Appeal Decision

Appeal Ref: APP/C3105/D/21/3273937

Heath Barn, Sibford Gower, Banbury, Oxfordshire OX15 5HQ

- The appeal is made under section 78 of the Town and Country Planning Act 1990 against a refusal to grant planning permission.
 - The appeal is made by Mr Blackwell against the decision of Cherwell District Council.
 - The application Ref 20/03409/F, dated 24 November 2020, was refused by notice dated 9 February 2021.
 - The development proposed is a single storey, connecting link between the garage and the original barn conversion dwelling.
-

<p>project Heath Barn Sibford Gower Banbury OX15 5HQ</p>	<p>drwg no 213_05_301 rev P1 title Proposed Elevations E + W scale 1:100 @ A3</p>
--	---

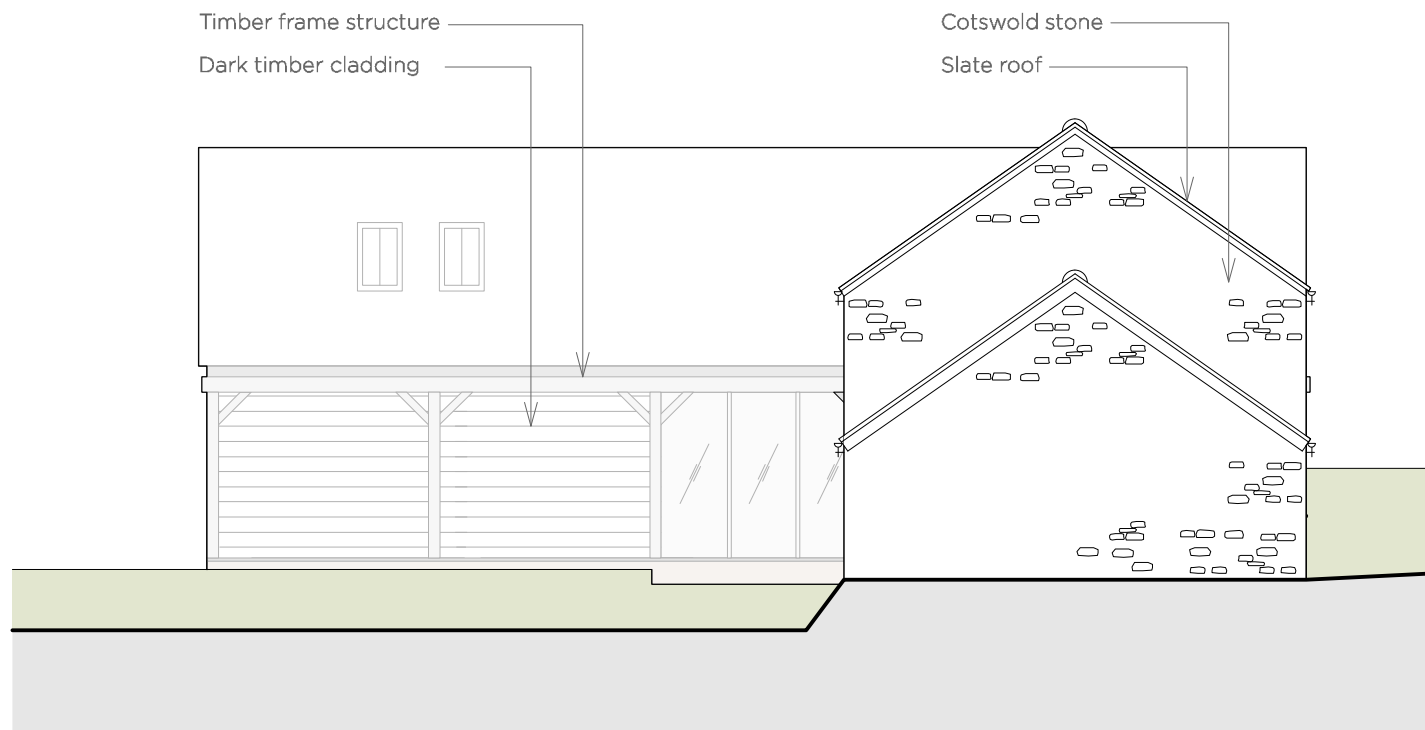
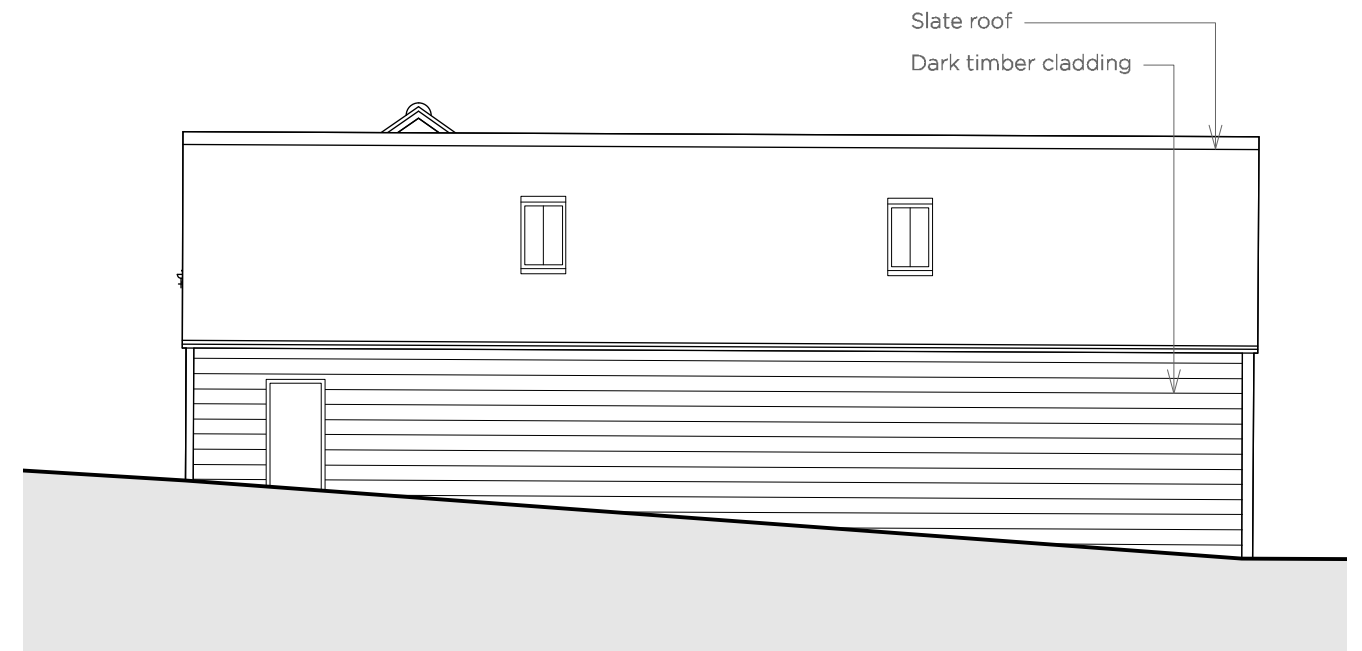
8. The proposal would introduce a single storey linking extension at the north-western end of the barn conversion such that it would connect with the detached garage building. The linking section would be a contemporary largely glazed structure with a flat sedum roof. The appearance of the extension would deliberately contrast with the traditional form and materials of the original converted barn. The resulting footprint would be a broadly L shaped arrangement inconsistent with the simple linear form and modest character of the original rural building. Furthermore, joining the built form together would necessitate an additional opening in the original fabric of the gable end.

1 Proposed Elevation - South  
Scale: 1:100

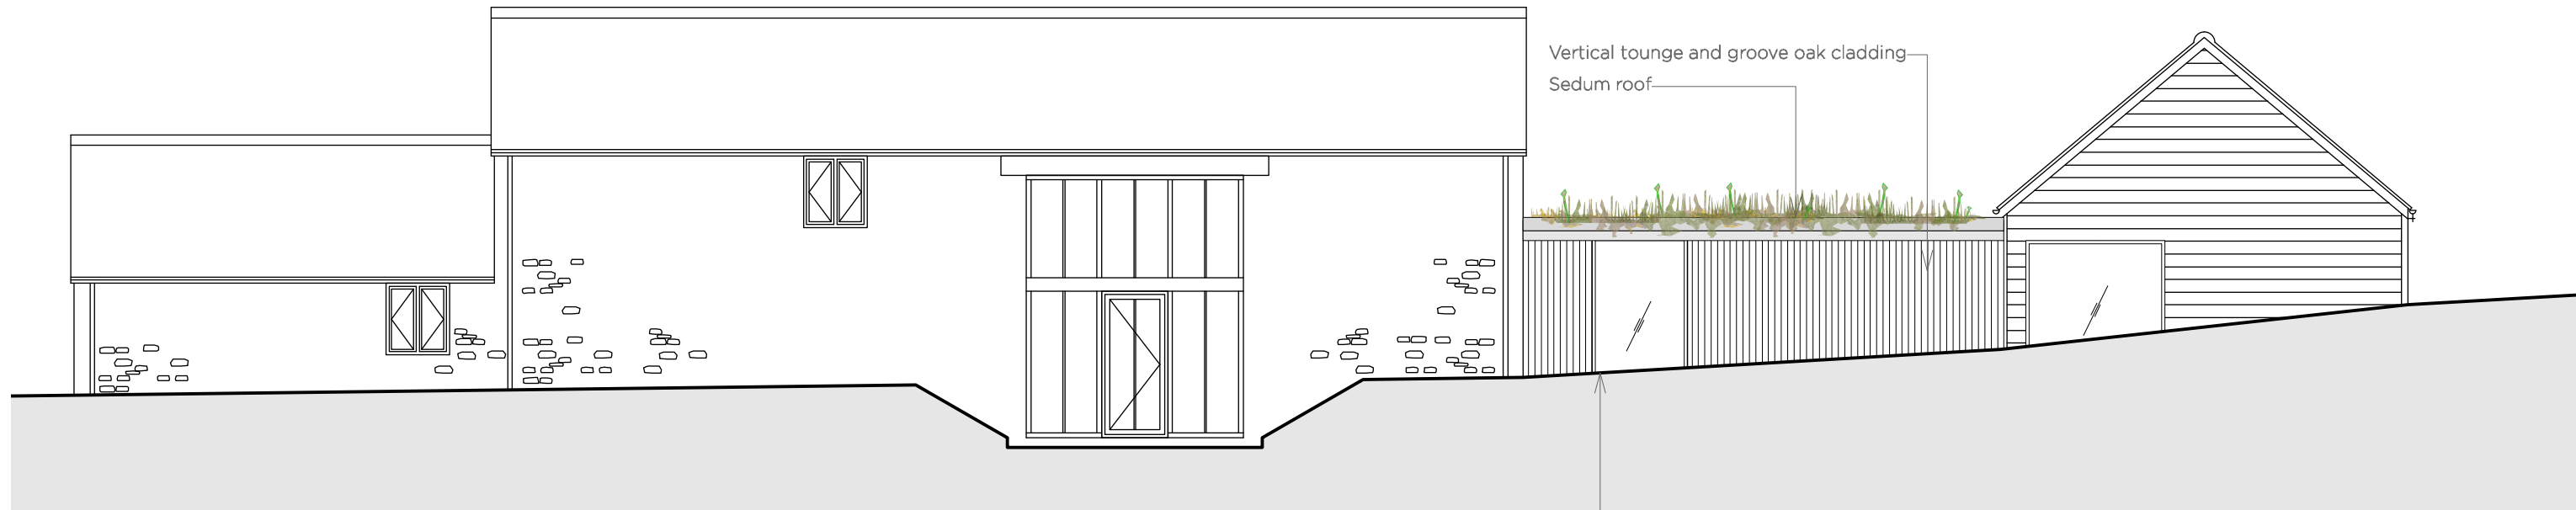
10. Notwithstanding its set back distance from the B4035, my observations were that the site can be seen from the road, as well as in more distant views from several directions. This is reinforced by the landscape impact assessment and photographs provided⁴ which illustrate that some glimpses would be possible from public rights of way. Accordingly, contrary to the appellant's assertion that views of the site are limited, the open countryside setting of the appeal site affords a notable degree of visibility. The presence of the proposed extension would, to a degree, harmfully obstruct views of the largely intact north-western gable end of the barn conversion. Furthermore, the significant amount of glazing introduced by the link as well as the new windows serving the proposed bedroom in the garage building, would mean that the proposed

development would be more noticeable in views when internally lit. This would exacerbate the degree of harm.

11. Whilst hedgerows and trees may limit the extent of the harm by providing some screening, this would not fully overcome my concerns, especially given that some trees and hedgerows would not always be in full leaf. Moreover, I am not convinced that the recently planted Yew hedging highlighted⁵ would remain at a significant height directly in front of the proposed study, or bedroom windows shown on the northern elevation, as to do otherwise would compromise the amount of natural light to those rooms.
